# **Able Marine Energy Park**

*Material Change 2*

**Amendment Order**

### The Able Marine Energy Park (Amendment) Order 202[ ]

**Works Plan - Key Plan**

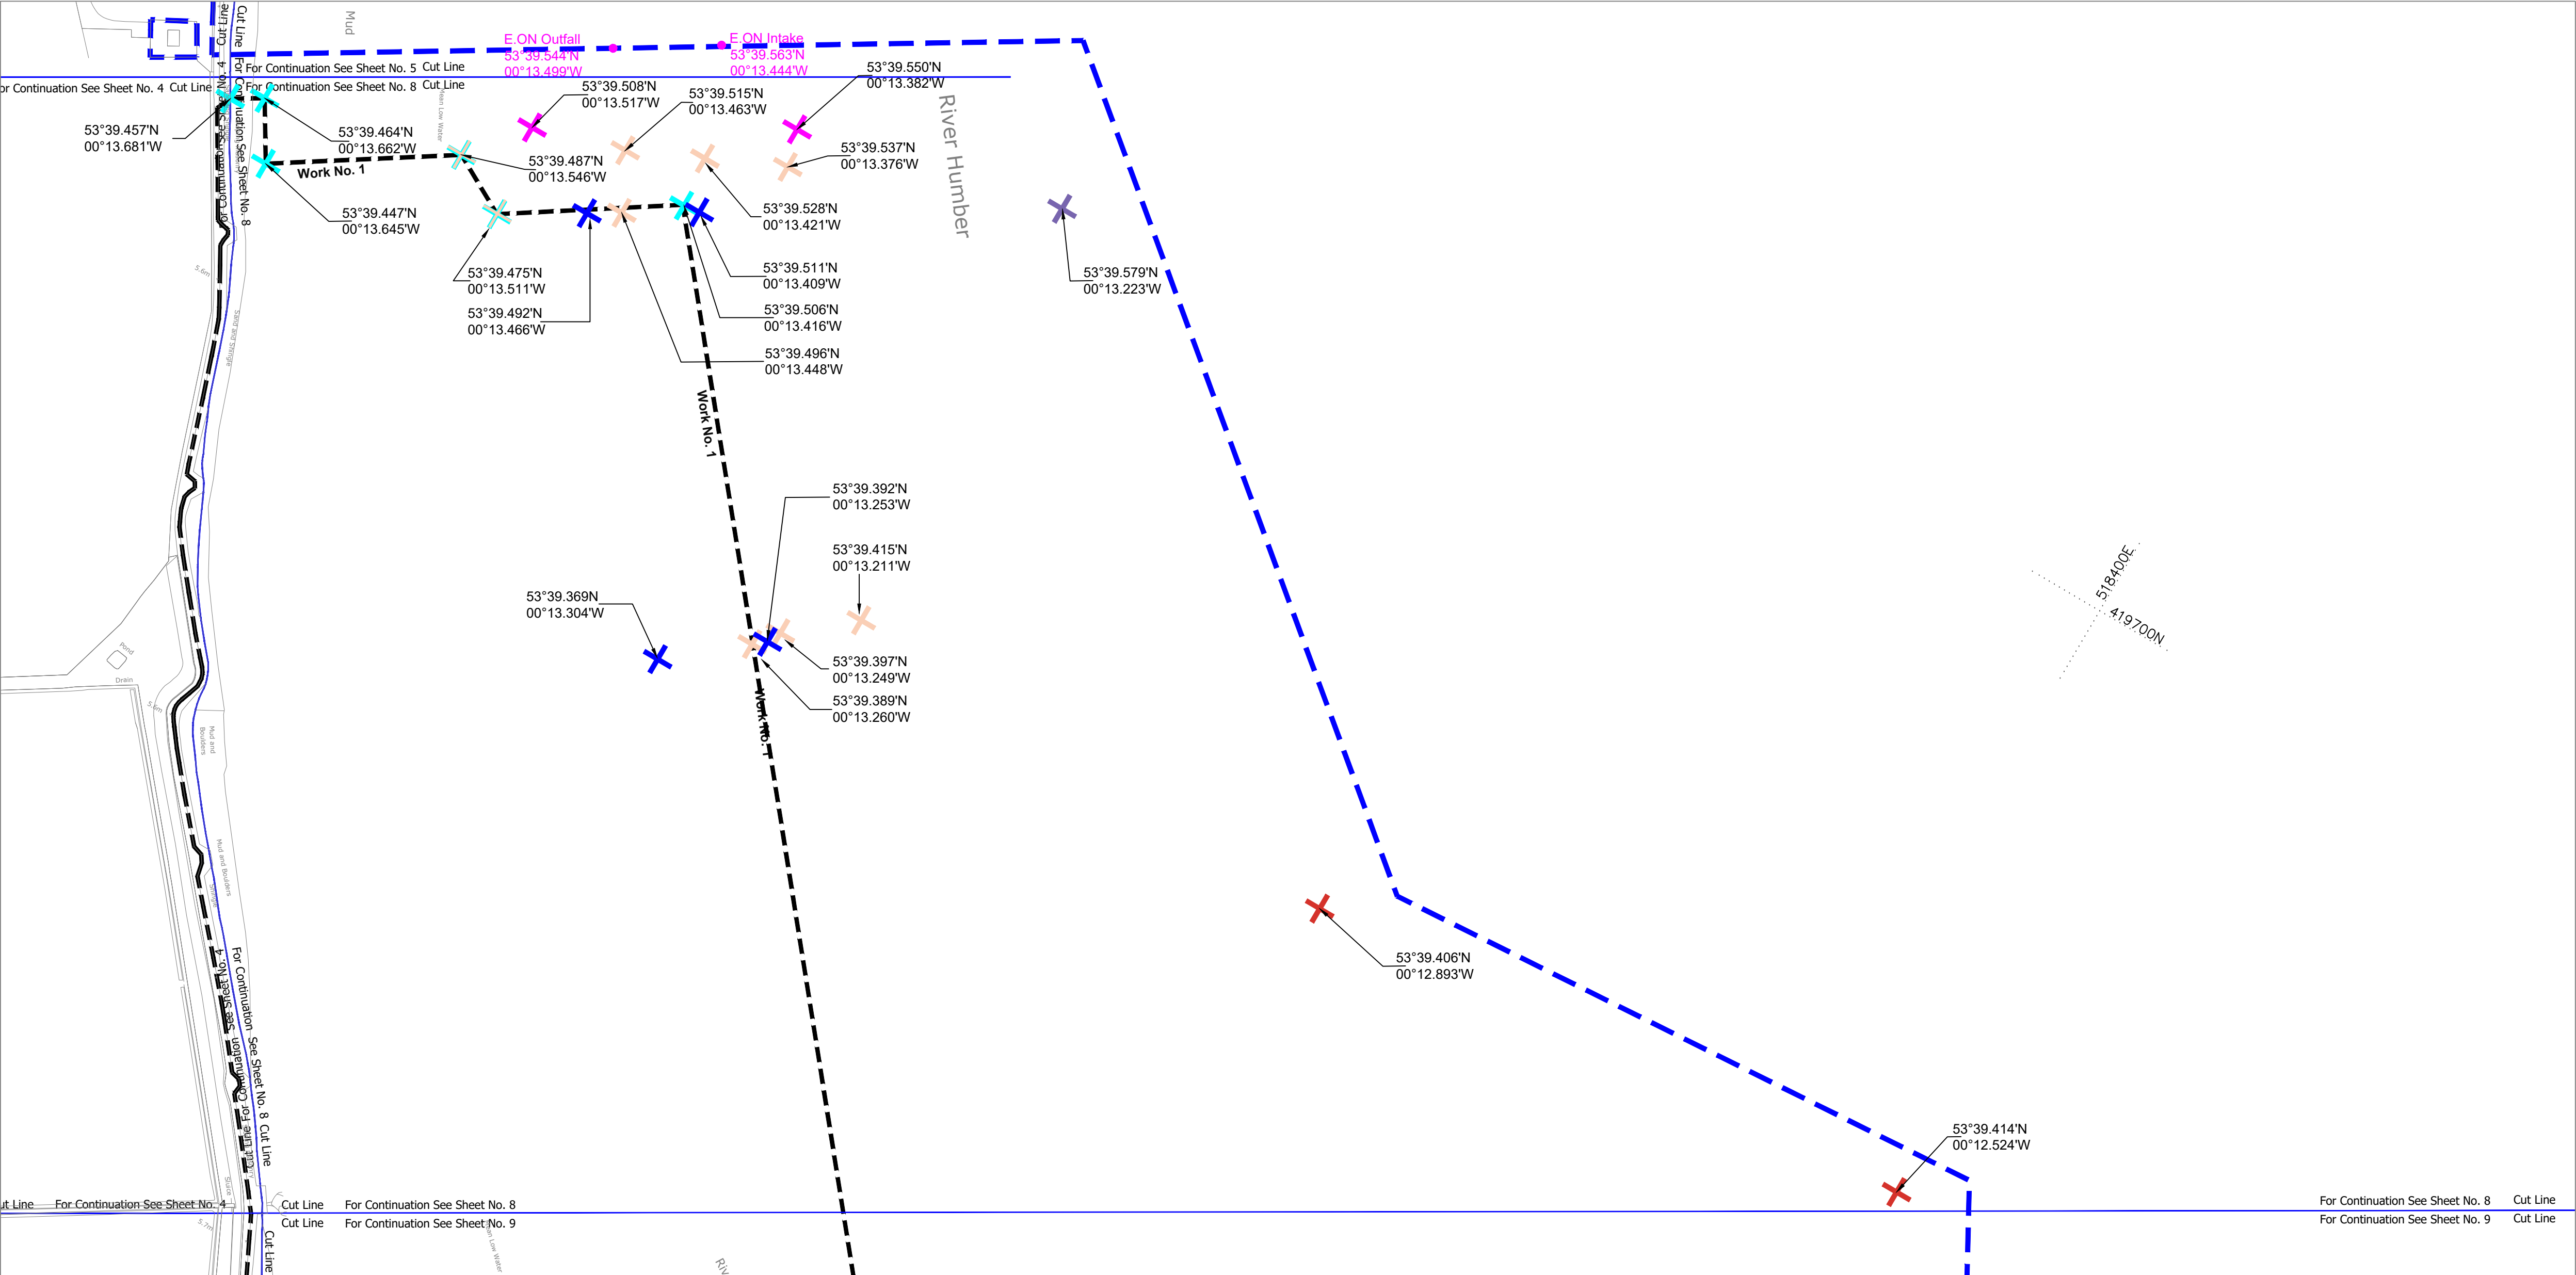
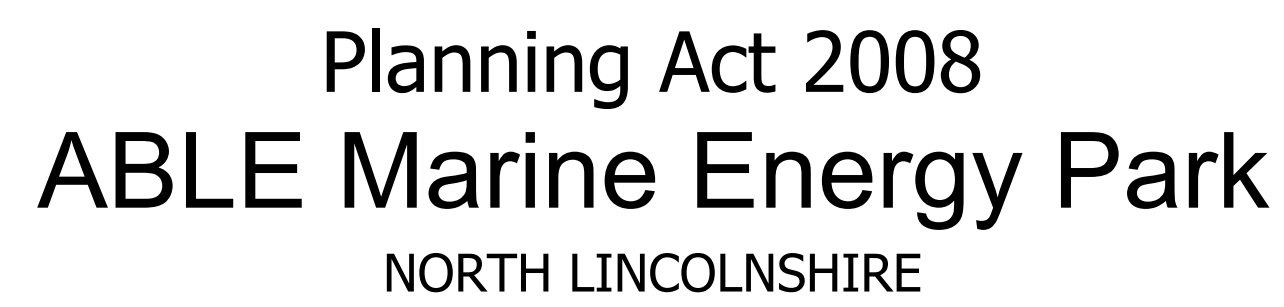
““the inset berth” means the area bounded by co-ordinates (53°39.492’N, 00°13.466’W), (53°39.511’N, 00°13.409’W), (53°39.392’N, 00°13.253’W) and (53°39.369’N, 00°13.304’W) and shown on sheets 8 and 9 of the works plans;”.
